Reference: A/18/8/PL for Application for Variation of Condition 2 imposed under A/173/16/PL to read "the development to be carried out in accordance with the following approved plans ADC962/04 REVA, ADC962/13 & ADC962/14 relating to slight repositioning & change in size of building, revised position of rooflights on east, north & south elevations. This application affects the Character & Appearance of the Angmering Conservation Area at Land Rear of 1 To 6 The Cottrells Angmering

I am writing to object to the additional drawing ADC962/18 showing the amended footprint that has been submitted for this application. The construction of the building has been completed but the drawing does not match what has been built with regards to the internal layout of the ground floor.

A		Layout amended		10.11.17	
Rev		Description		Date	
Job Reference		Client			
New House The Cottrells Angmering, BN16 4AF		AM Homes Ltd			
Drawing Title		Drawing No		Rev	
Ground Floor Plan		ADC962/04		A	
Date	Scale	Dwg Size	Plot Style	Drawn	Checked
24.04.17	1:100	A3	ADC-red	TGS	AD

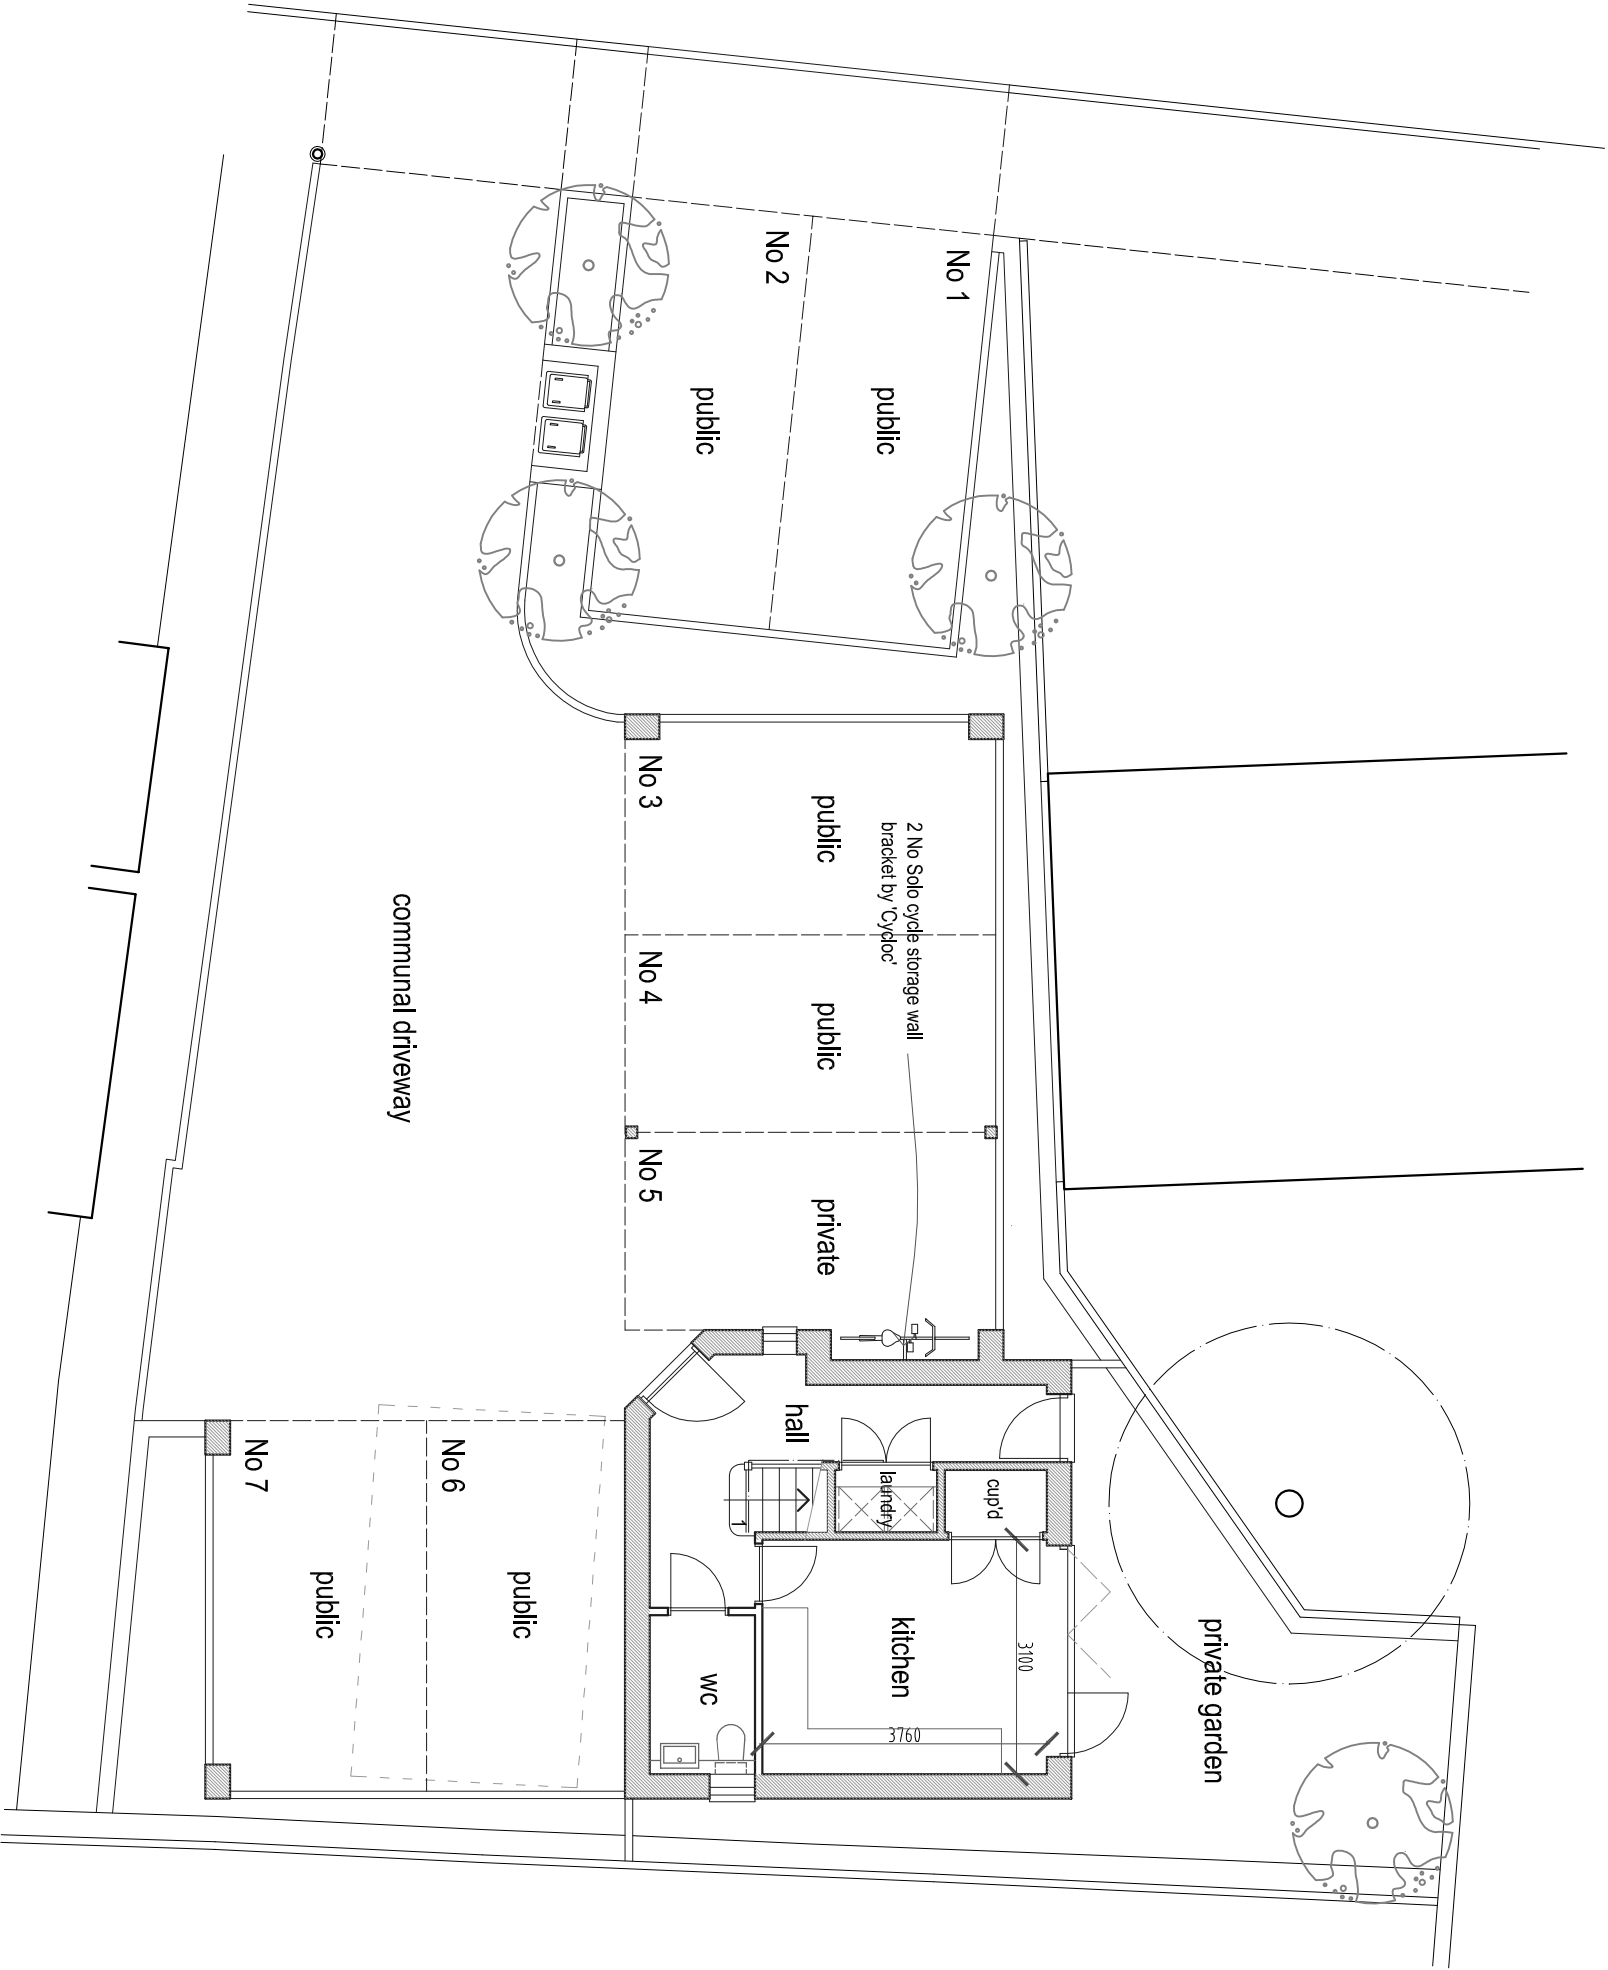
The as built layout matches that in drawing ADC962/04 submitted for application A/162/17/PL with Bedroom 1 with an en-suite shower room downstairs. This application was refused in 2017.

Drawing Title	Drawing No	Rev
Planning Permission	ADC962/18	
Comparison Plan

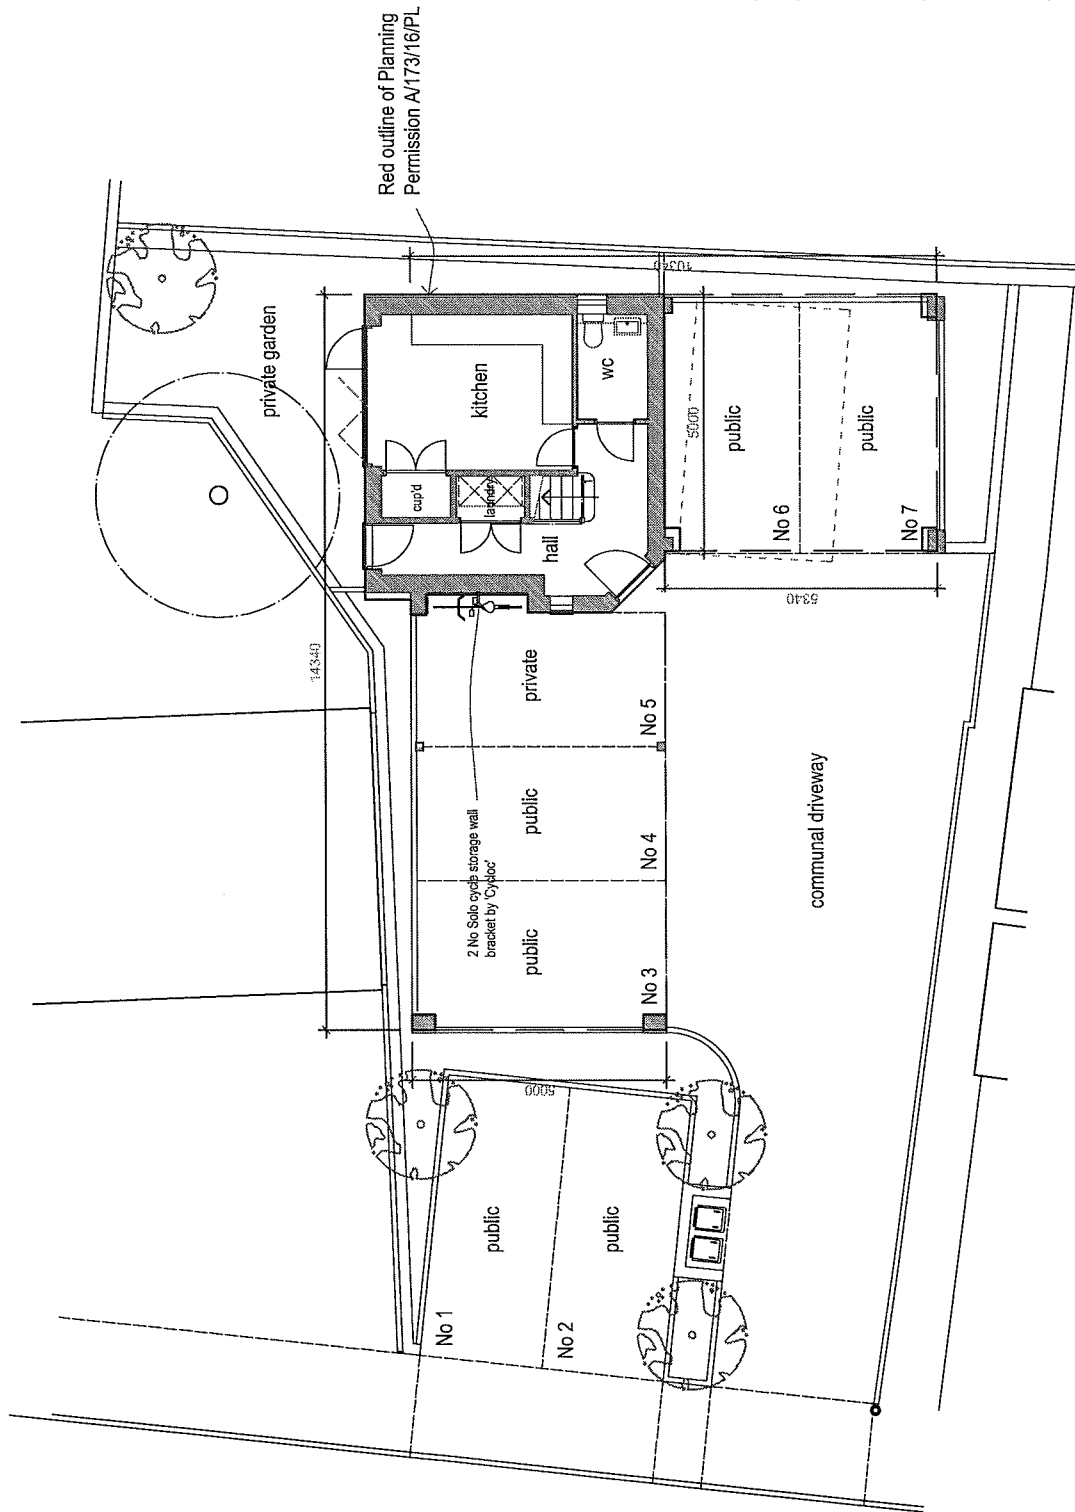
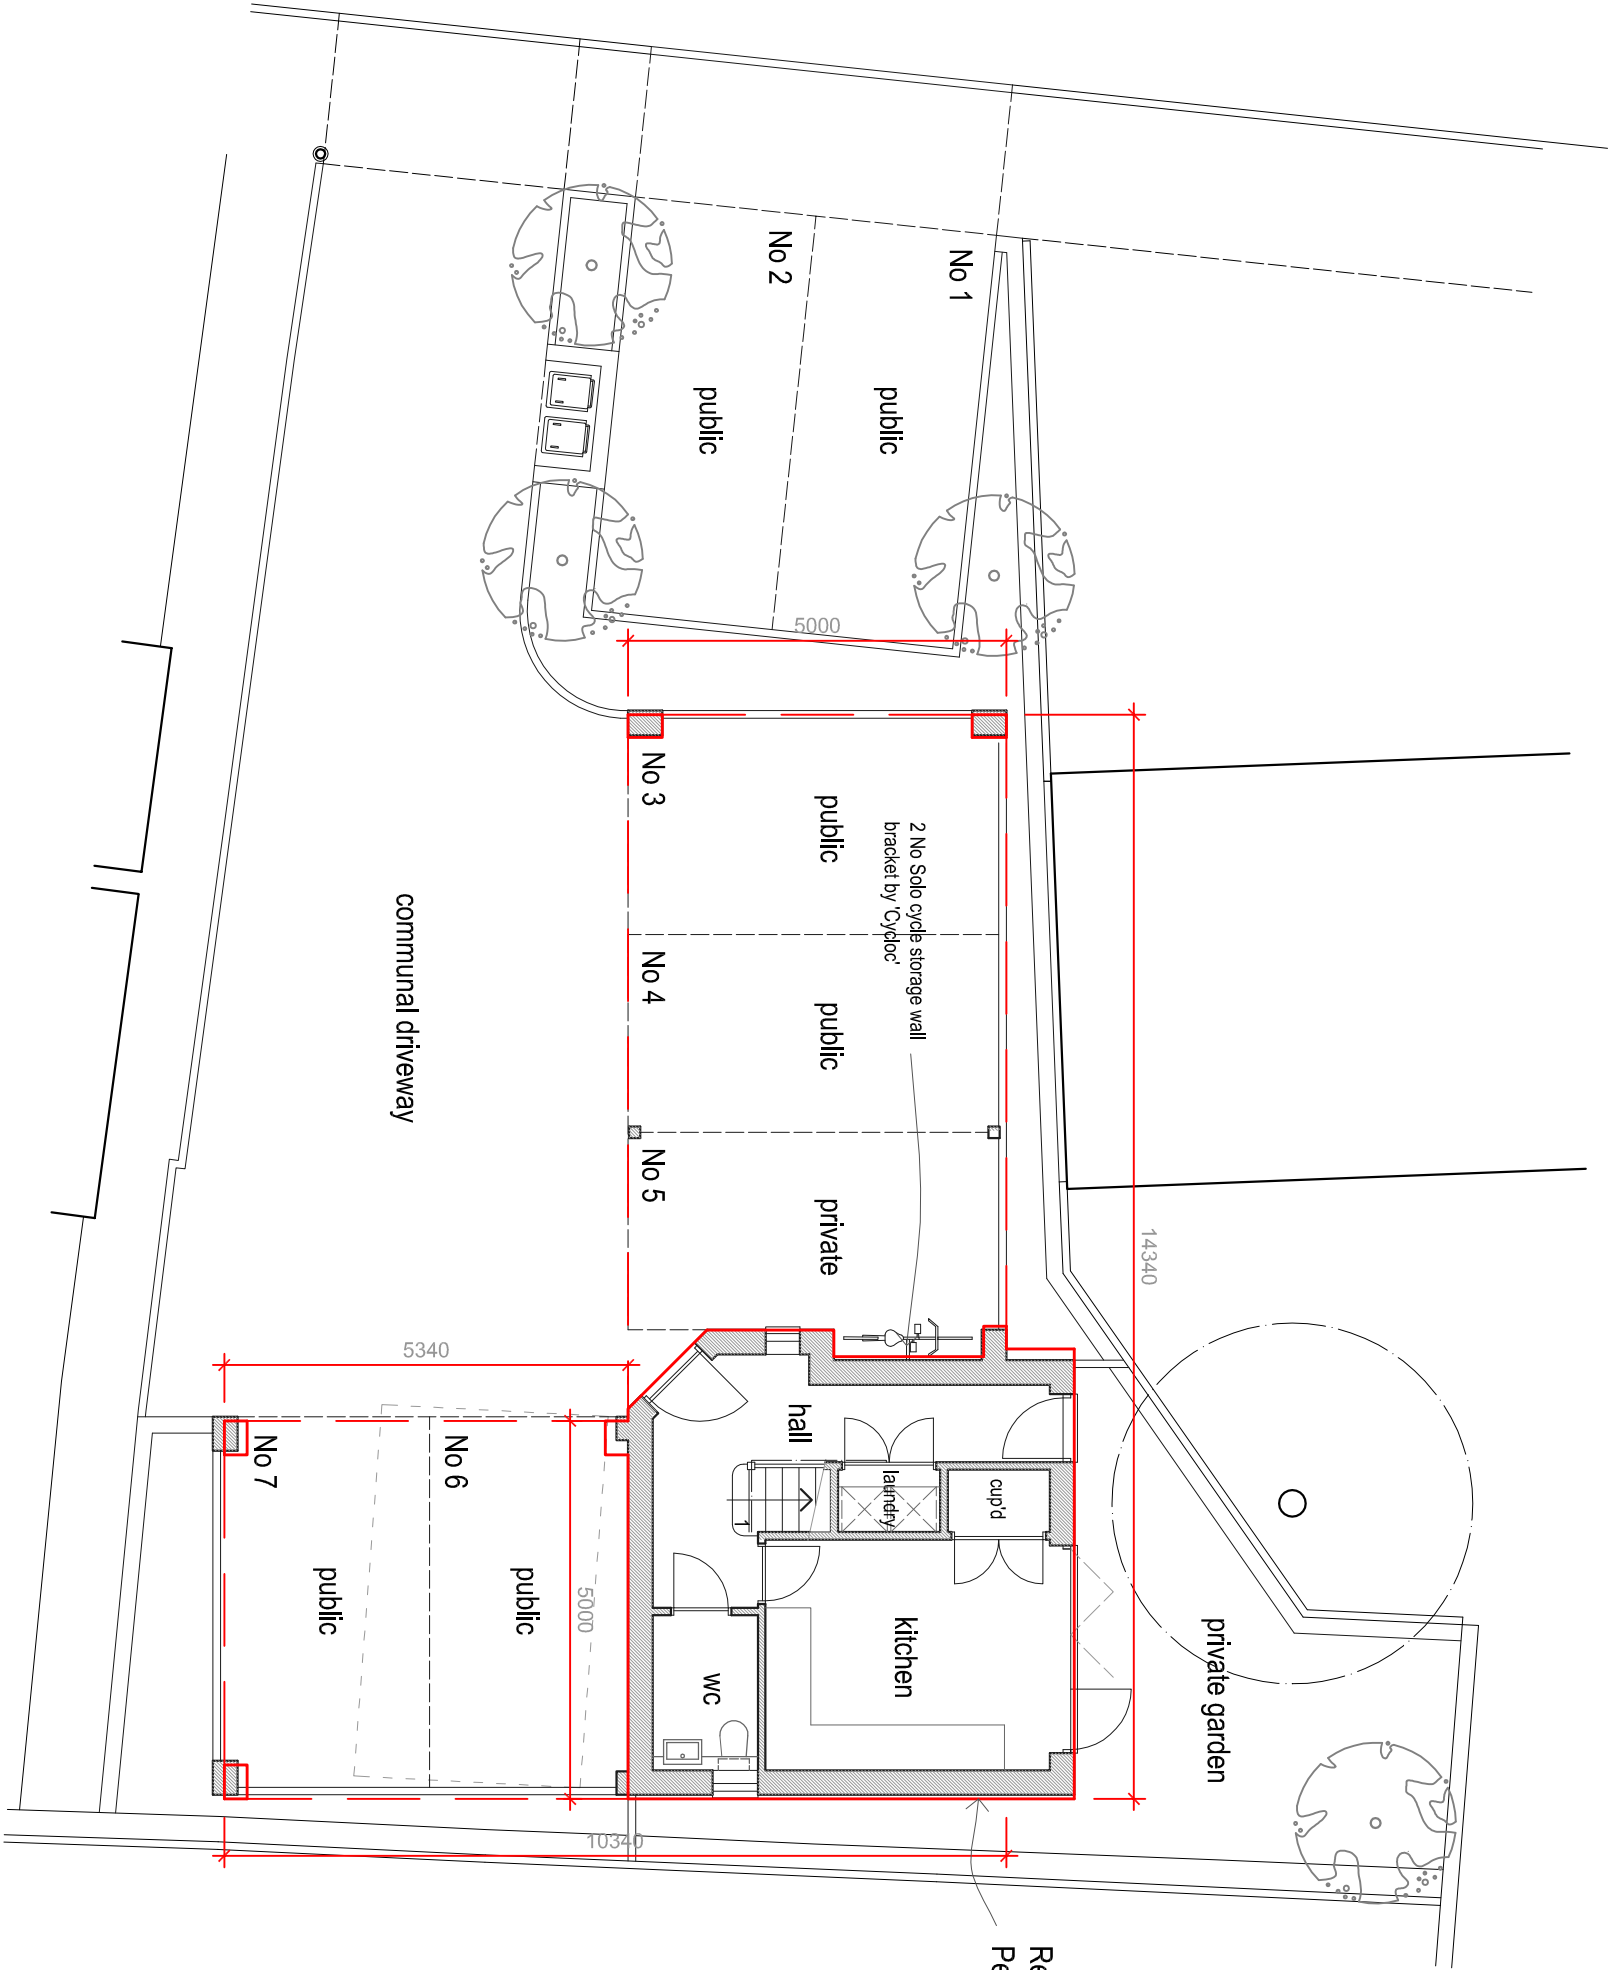
As built, there is a new door within the room identified as the KITCHEN that opens into what is identified as the WC. A shower cubical (with chrome edging and handle) can be clearly seen in this room. Also from my viewing angle, there do not appear to be any mains sockets in the walls at worktop height which is a common feature in all kitchens.

Neither the door or shower are shown on drawing ADC962/18.

Condition 2 of Conditionally Approved A/173/16/PL identifies that no external or internal changes are permitted without approval. The downstairs layout appears to have been built as a bedroom with en-suite shower room, not a kitchen plus WC.

The submitted plans therefore do not match what has been built. Can they be considered as a valid document for the application?
